22 July 2022

RE: NEWCASTLE JOCKEY CLUB STABLE DEVELOPMENT (SSD-12982045)
RESPONSE TO REQUEST FOR FURTHER INFORMATION DATED 14 JUNE 2022

OVERALL GROUND FLOOR PLAN

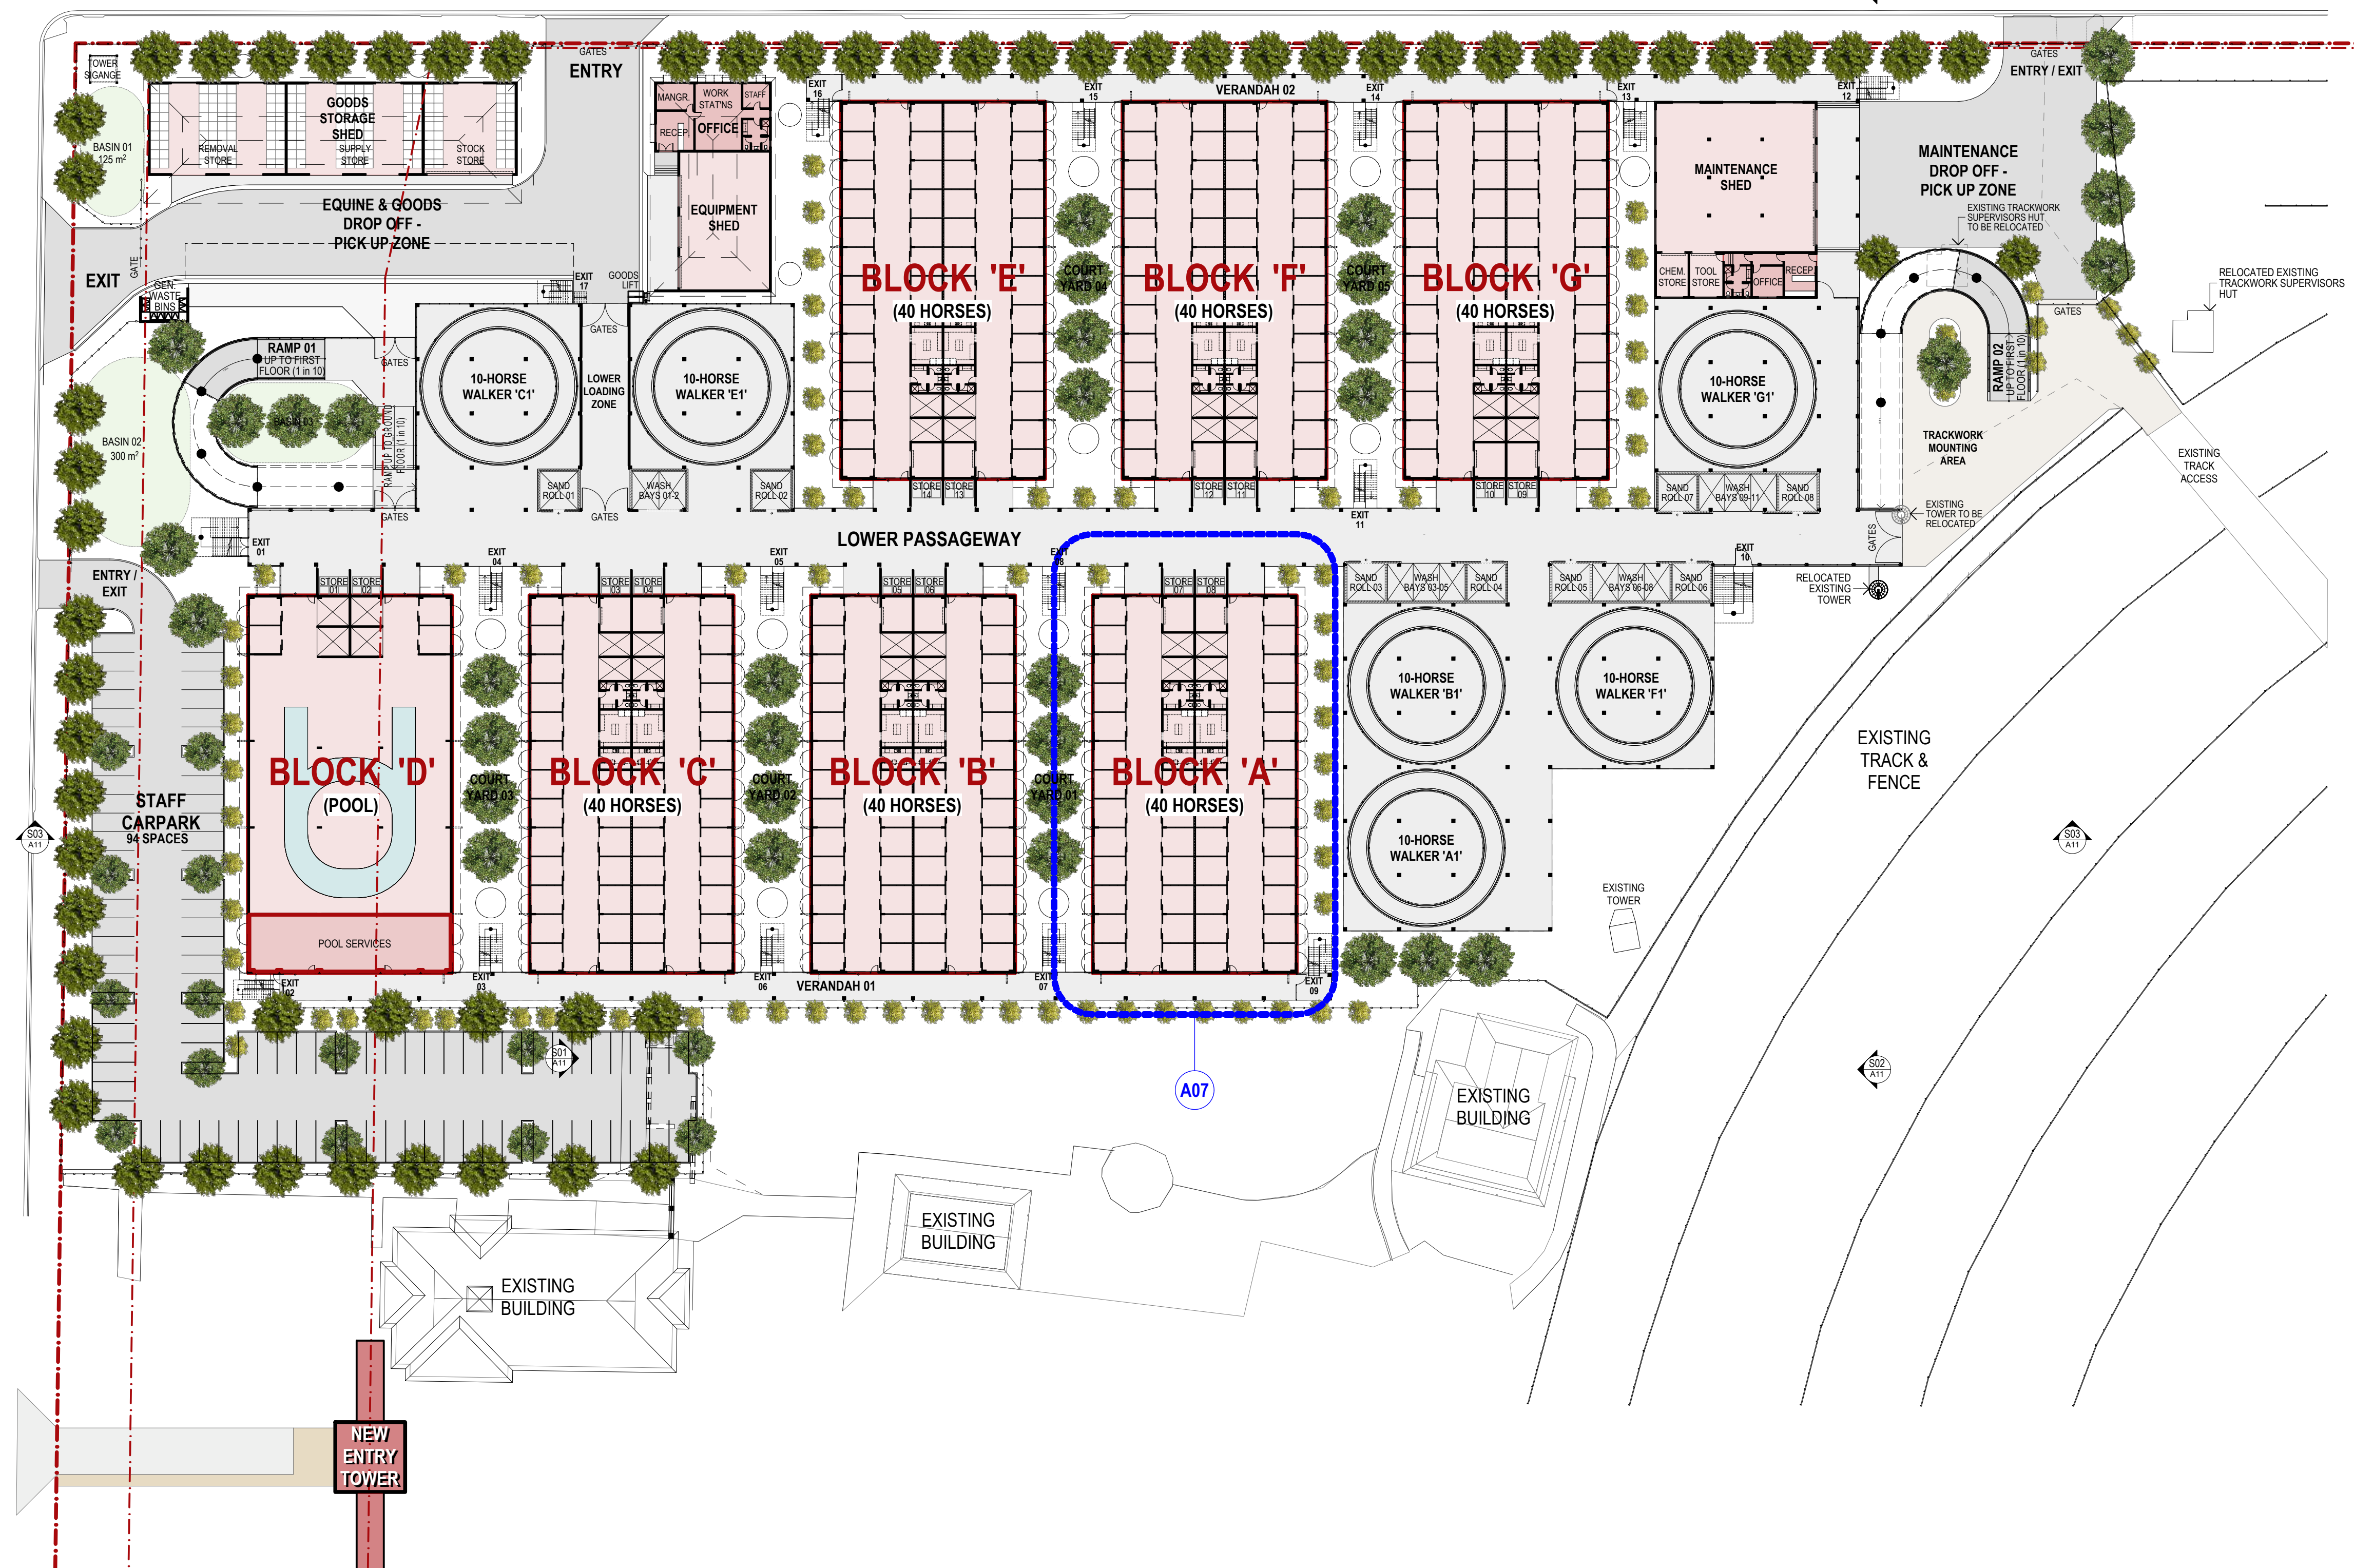
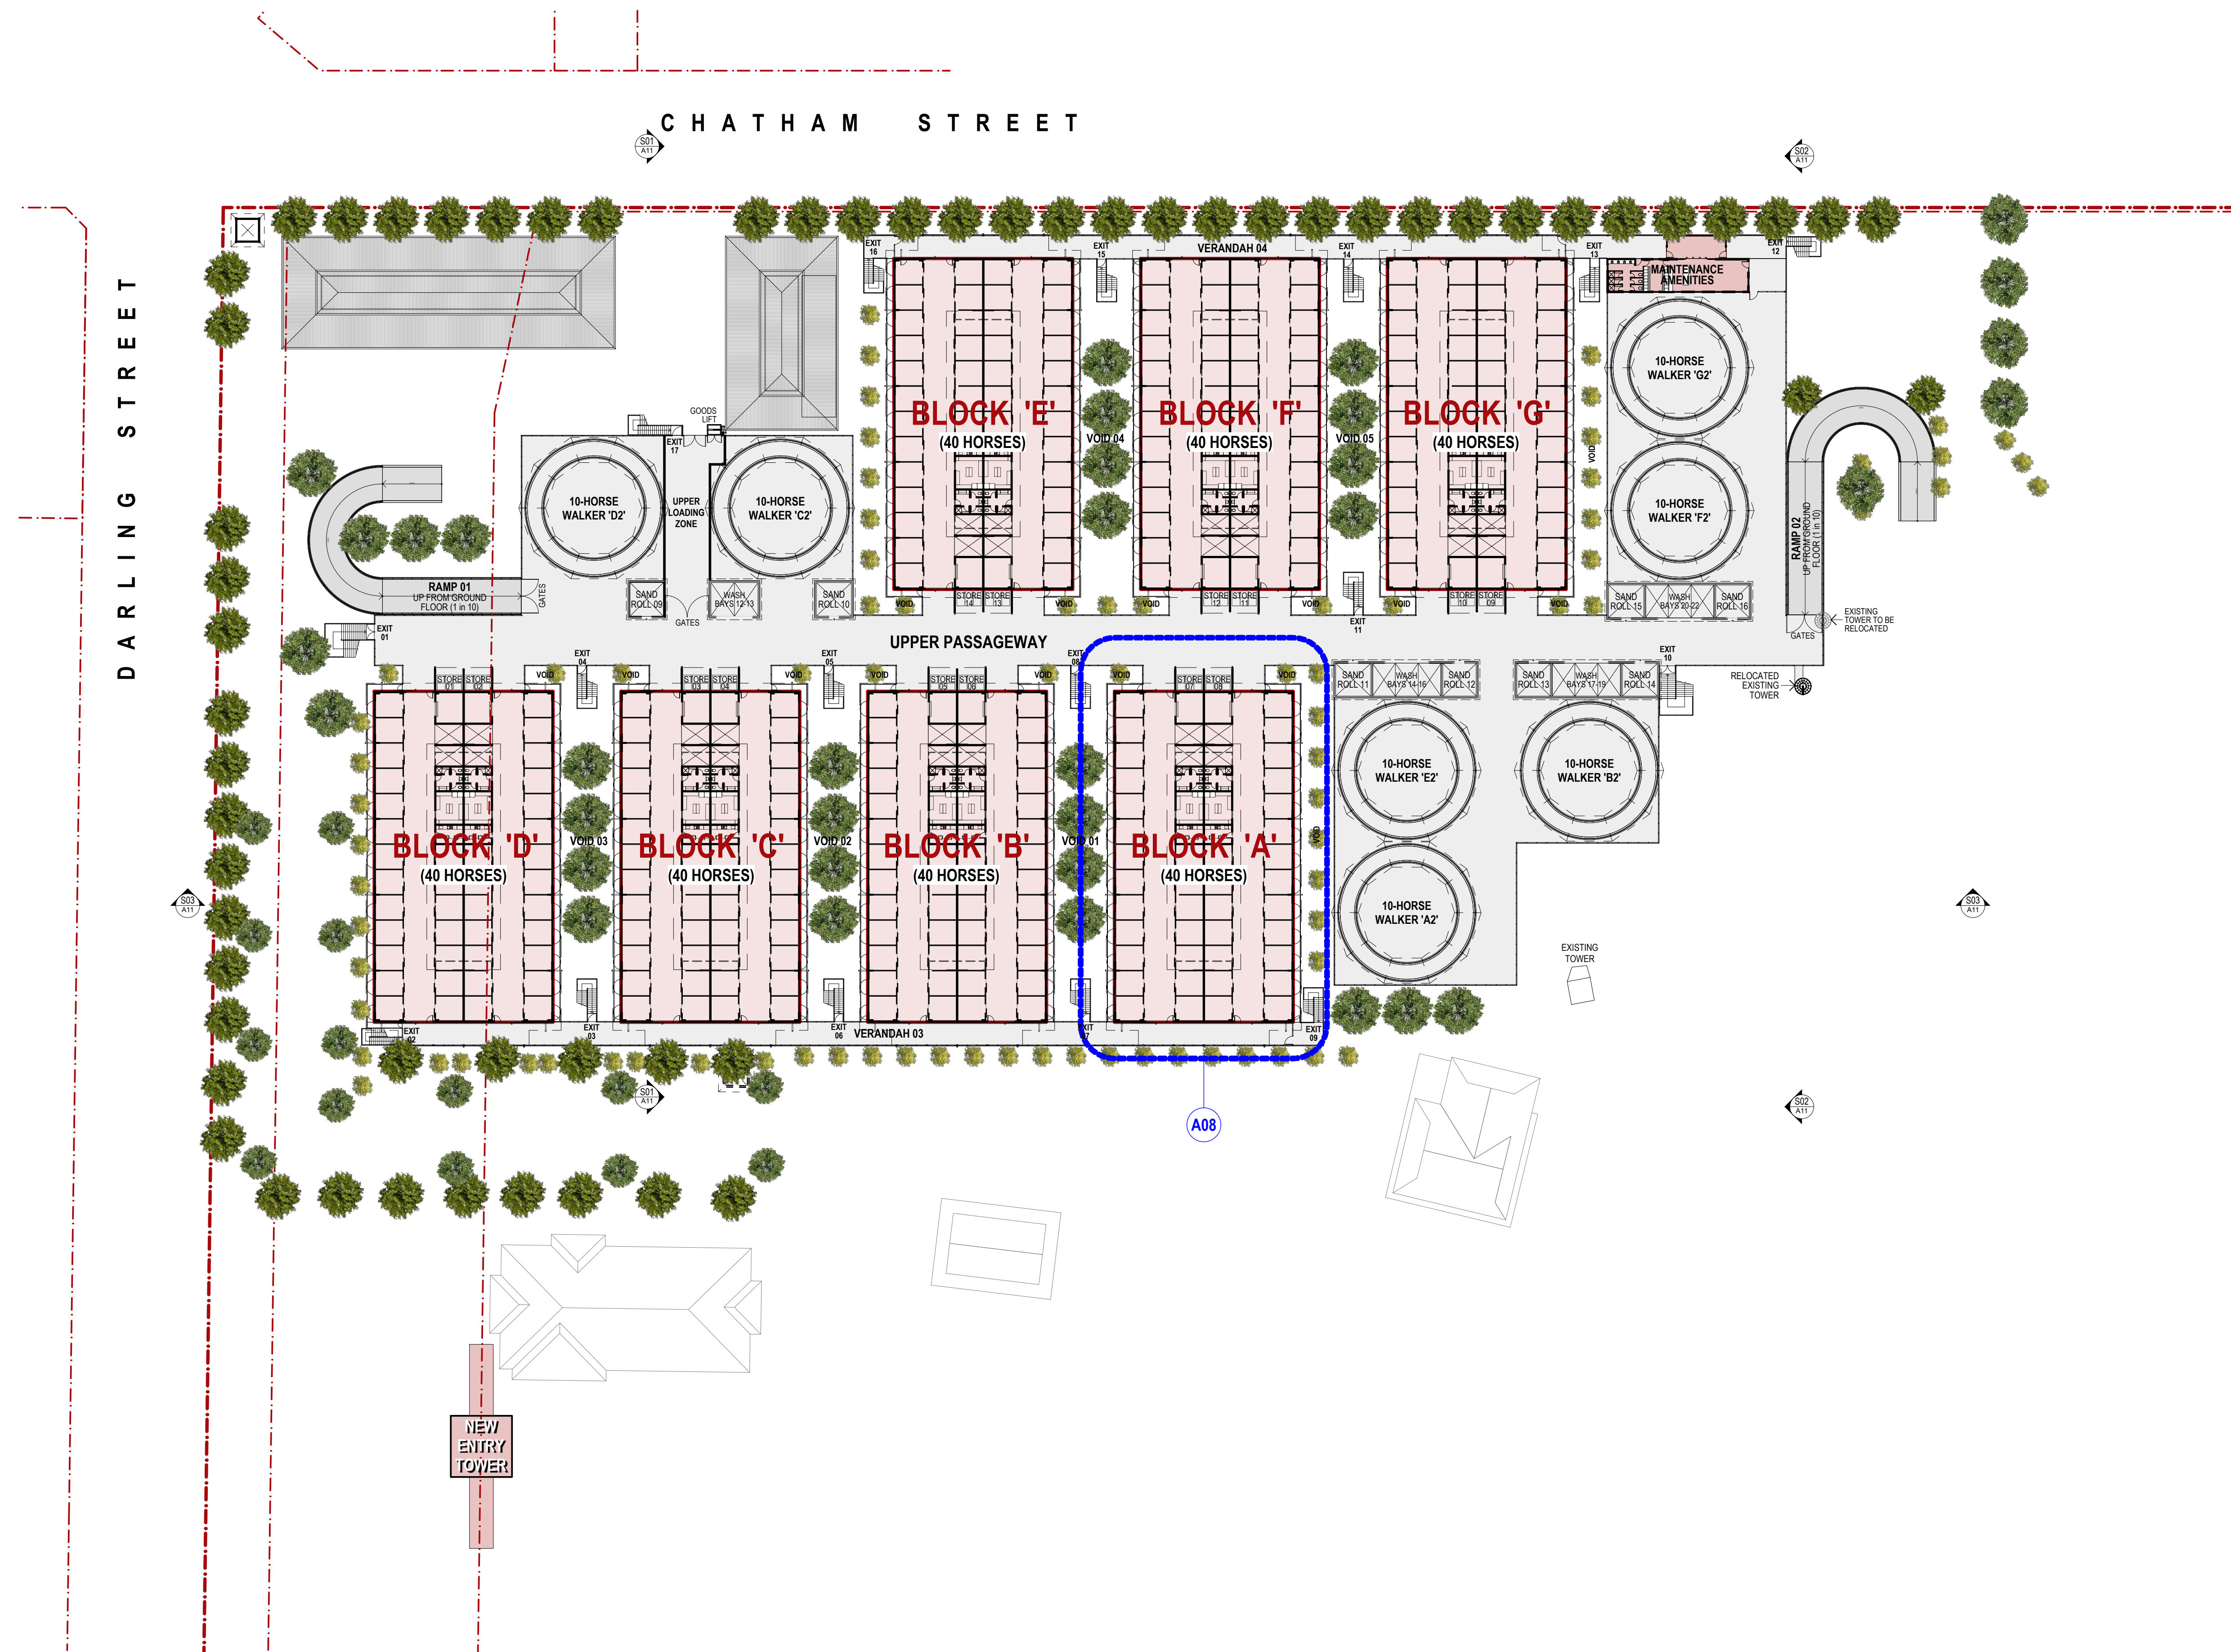
- i. Gate Setback:
 - a. Gates have now been set back for the Chatham Street driveways as far as possible as requested by CN to mitigate the risk of vehicles blocking the road carriageway. Gates need to be sliding rather than hinged, such that internal space in the Pick up / Drop-off Zones are maximised.

For the Equine & Goods Drop off / Pick up Zone, the gates will be positioned approximately 5m back from the boundary, and in the open position will slide against the western wall of the Goods Storage Shed and Site Office.

For the Maintenance Drop off / Pick up zone, the gates will be positioned approximately 4m back from the boundary, and in the open position will slide into the landscaped area to the south, and against the outside running rail of the track to the north.

The fence gates to the staff carpark have now been deleted, as they are not required for equine safety. Additionally, the fence and gates would prevent Ausgrid obtaining access to the substation for maintenance purposes at the staff carpark.
